Please find enclosed a formal letter of objection on behalf of Aldingbourne Parish Council in respect of the current application at Woodgate Nurseries.

Your Ref:
AL/129/21//OUT

**Re: Application in respect of Land adjacent to Woodgate Nurseries, Lidsey Road, Aldingbourne
(Application Reference AL/129/21/OUT)**

Figure 19 - Access Proposals

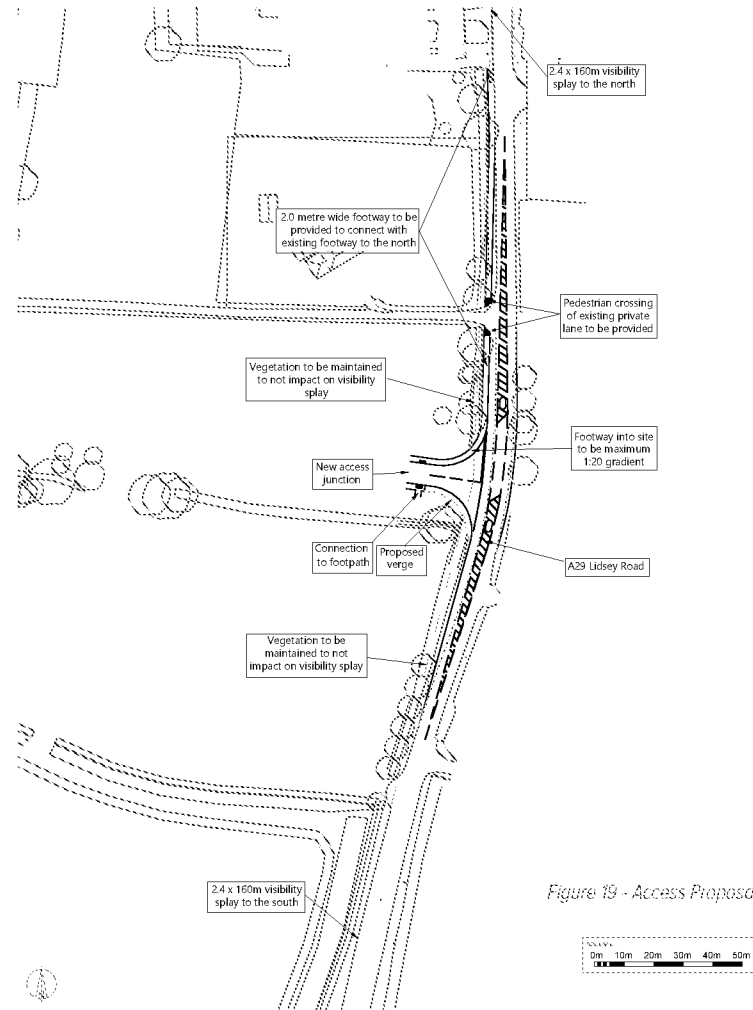
Based upon the information provided it is not clear how the proposed access will interact with the proposed junction arrangement for the Barnham, Eastergate, Westergate (BEW) development on the eastern side of Lidsey Road and in the absence of this information it would not be possible to rule out harmful impacts upon the safety and convenience of users of the adjoining highway, contrary to Policy T SP1 of the Arun District Local Plan.
